From  
THE SECRETARY,  
General Metropolitan  
Development Authority,  
No. 5, Gandhi Memorial Road,  
Chennai- 600 028.

Letter No. 32/10001/88

Sub. CM&A - AP - FF - Construction of Part Villa + 4 Floors and Part Ground Floor + 3 Floor building for 7 dwelling units at Plot No. 2, Crescent Road, Sherry Nagar in S. 20-24/1 & 40% of Peripetoidal Village - Possessions of S.O. and other charges - Proposed - Regarding.

Job Title:
PROPOSED APARTMENTS AT
D.No. 9, OLD PLOT NO. 9, CRESCENT
ROAD, SHENOY NAGAR, CHENNAI-600 008
BEARING S.No. 39/1, 40/5, OF
PERIYAKODAL VILLAGE FOR
MR. C. KASTURI (POWER AGENT)

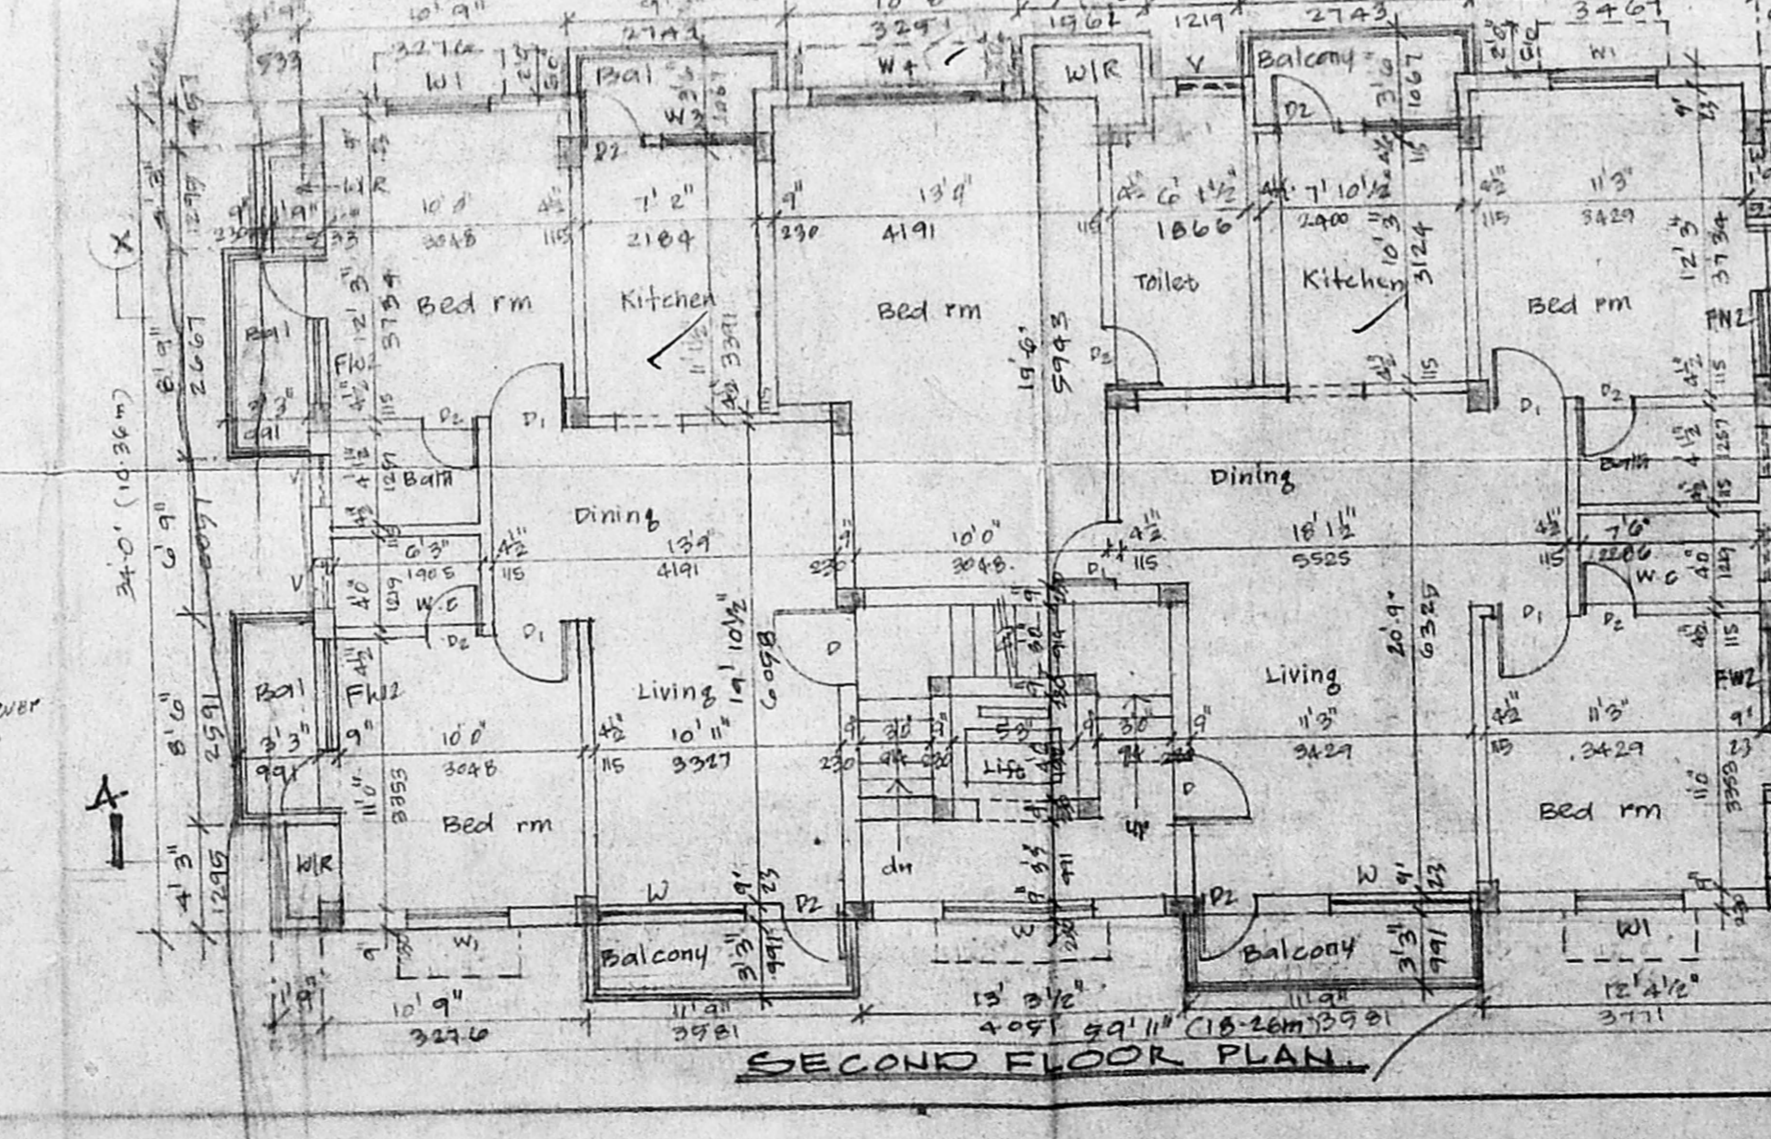
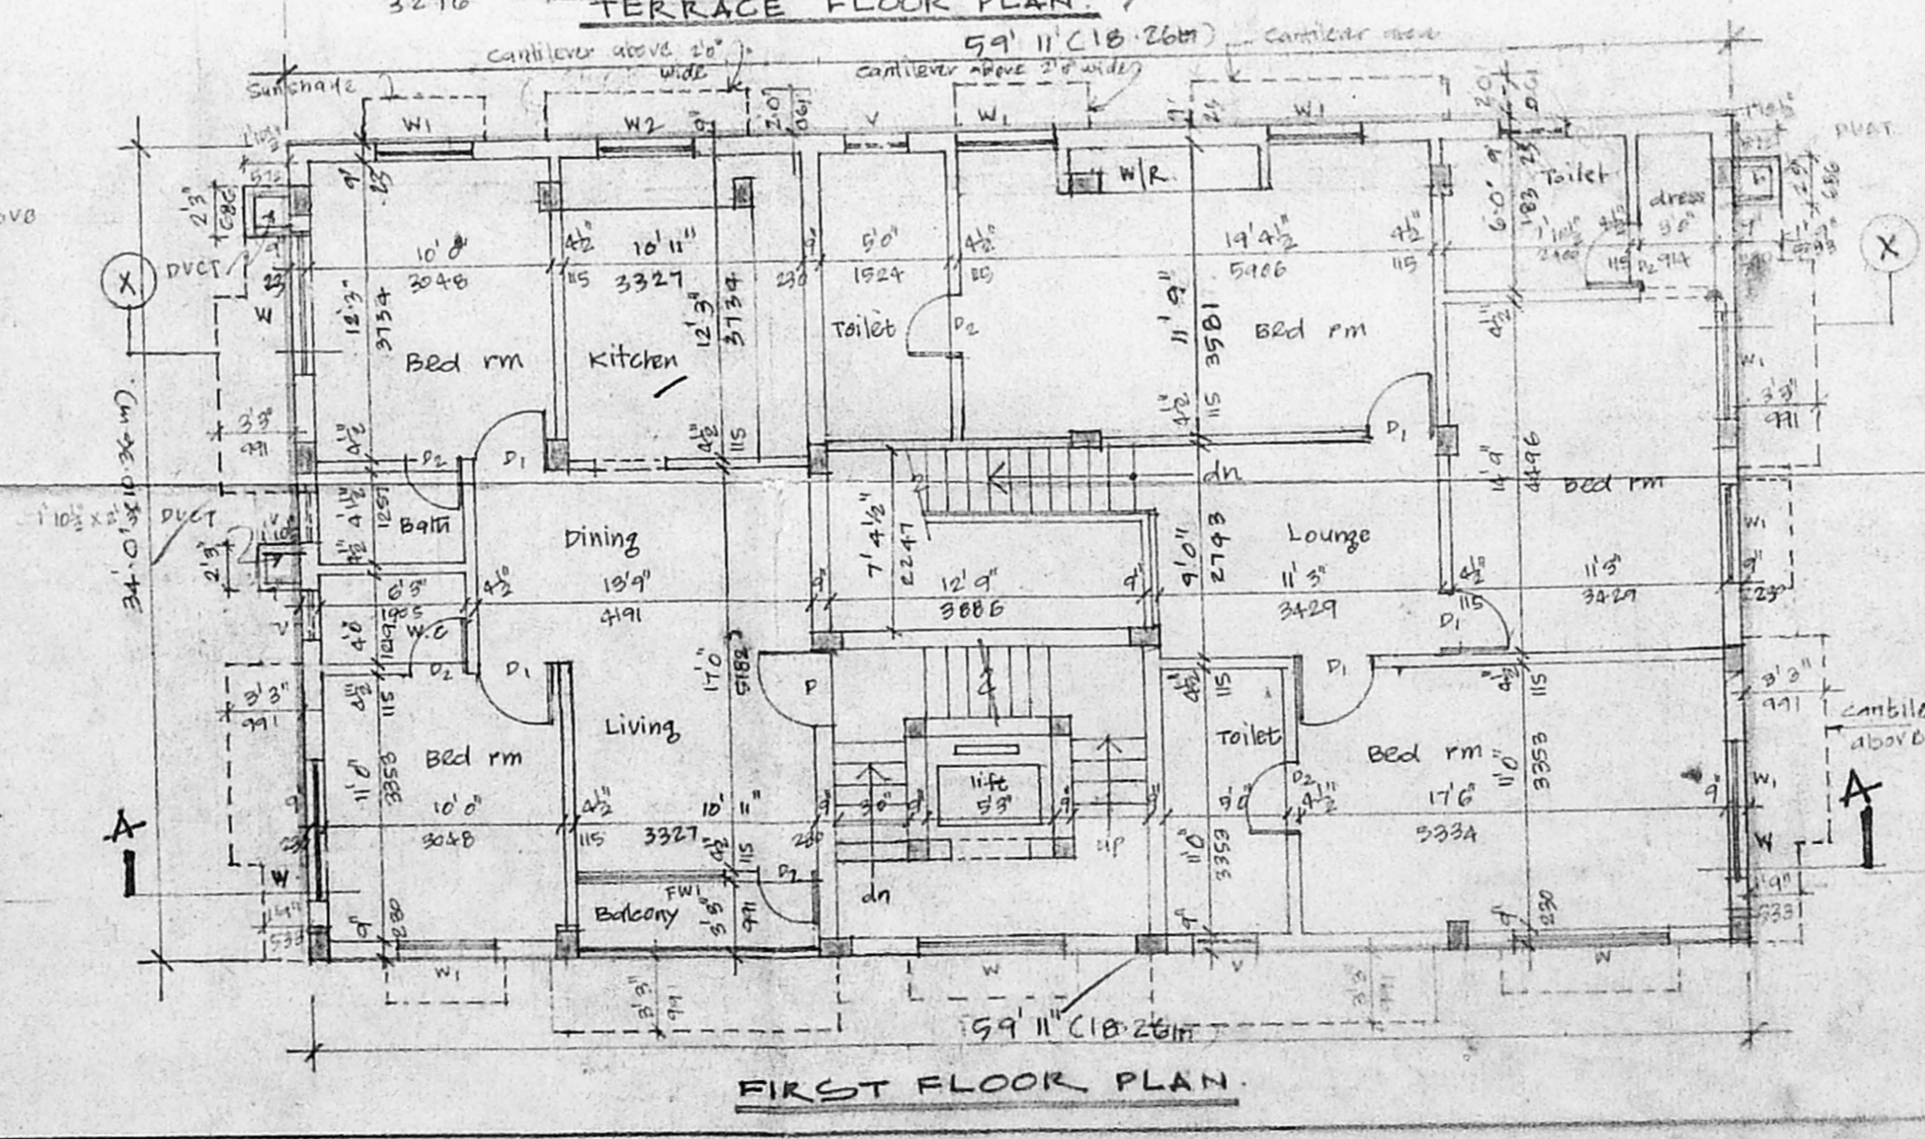
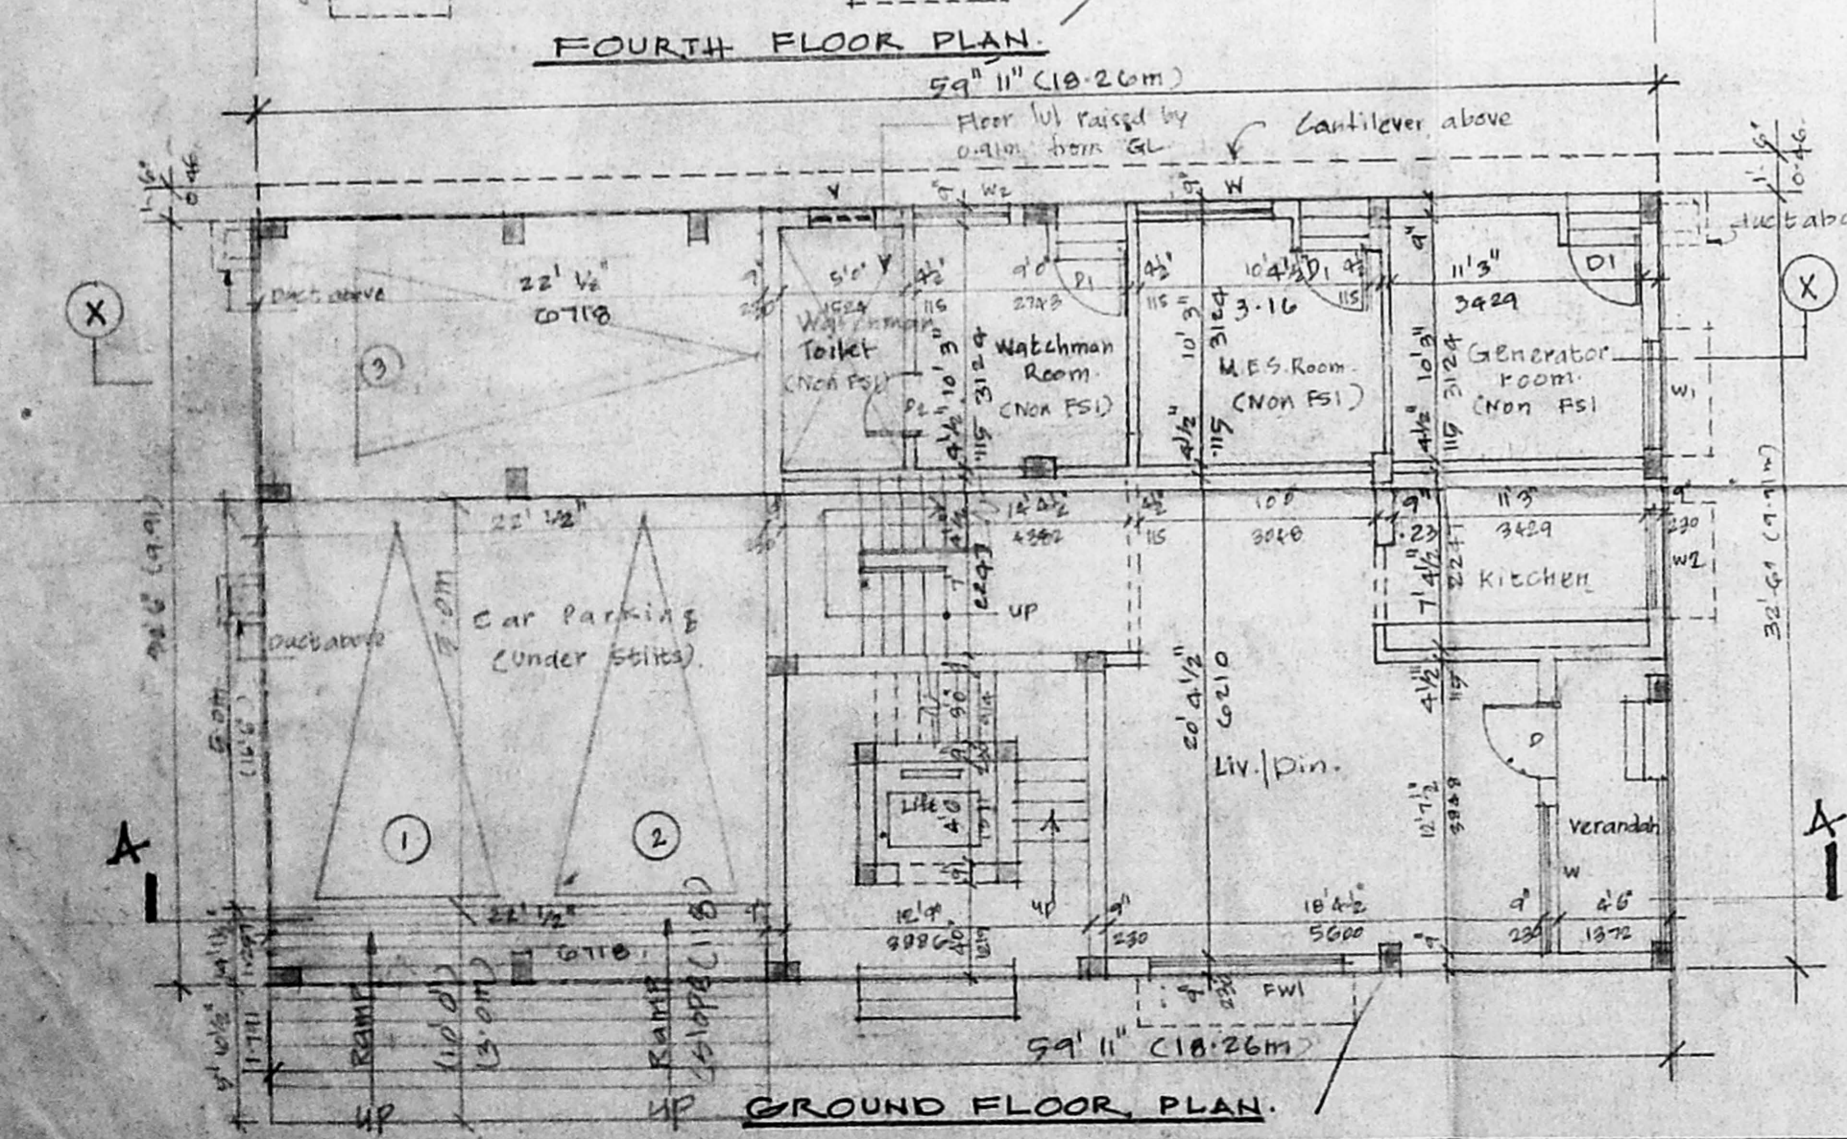
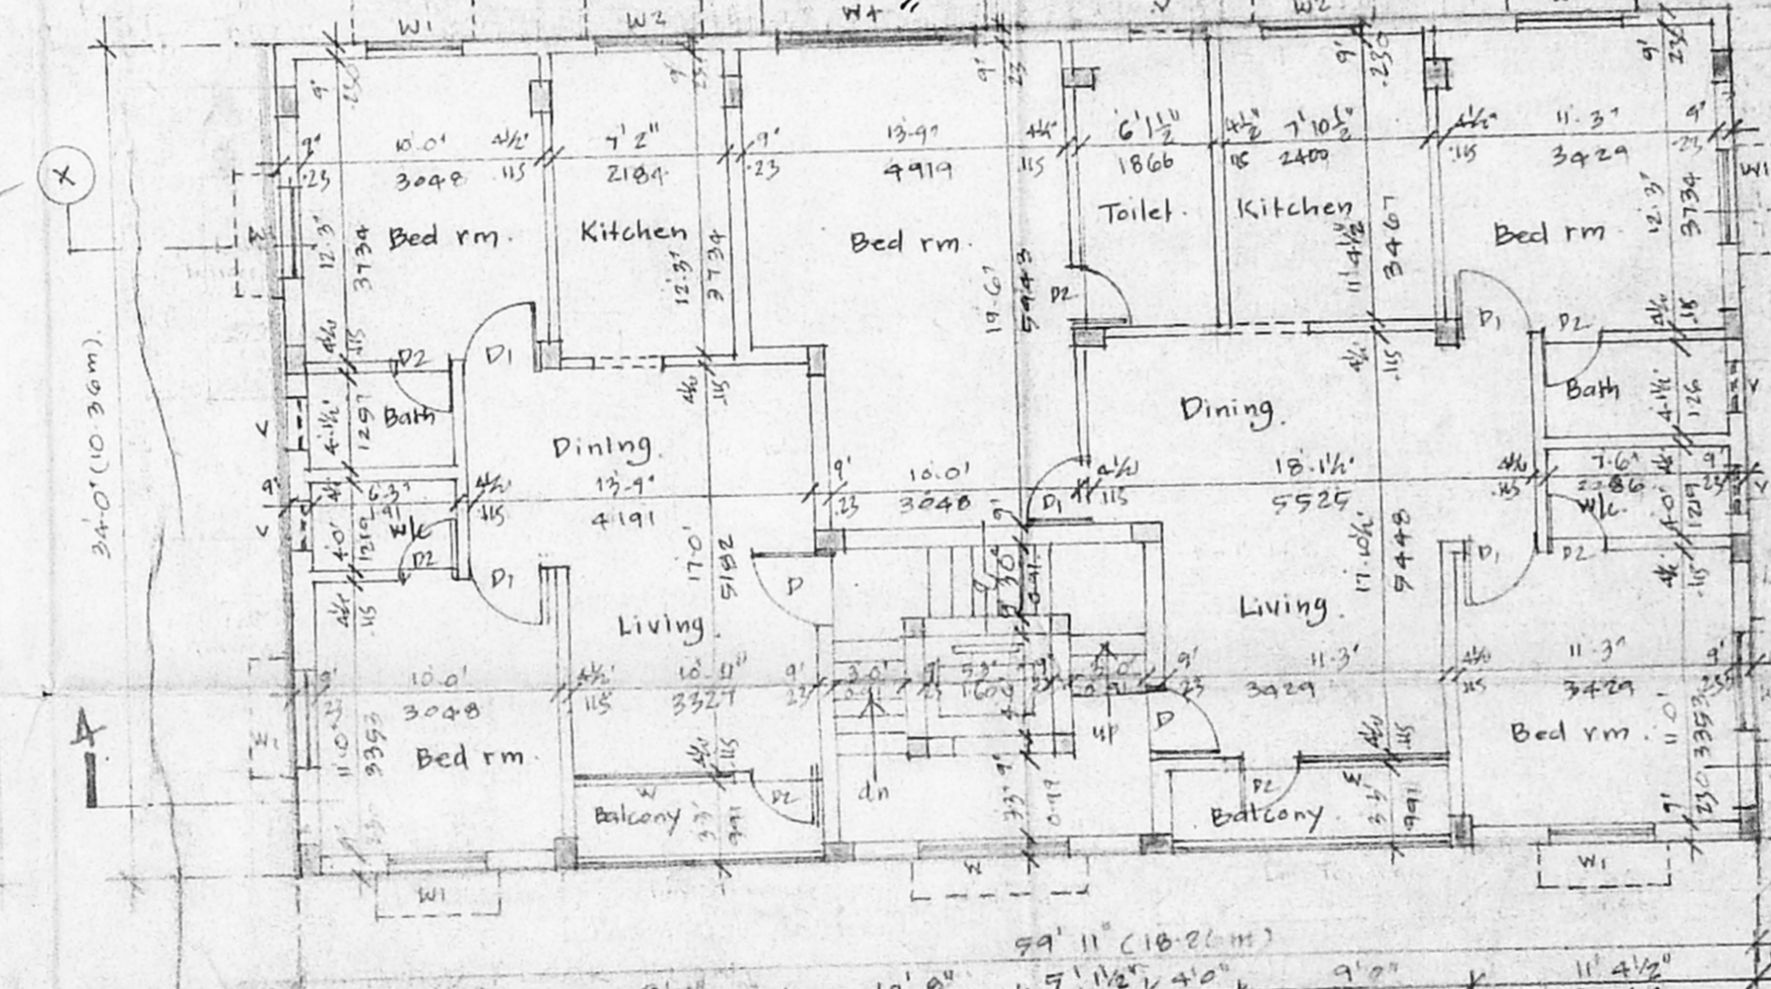
- 111.(c) You are requested to furnish five copies of revised plans complying with the following :-
  - (i) French window for the 2nd floor at 2nd and 3rd floor to be converted as ordinary window.
  - (ii) The floor level of stilt floor to be increased by 1'-0" from ground level and providing ramp at the stilt parking area.
  - (iii) Rain Water trench to be provided on south side also as provision of dummy slab may not be feasible.
  - (iv) Balcony & wardrobe projections to be indicated in site plan.
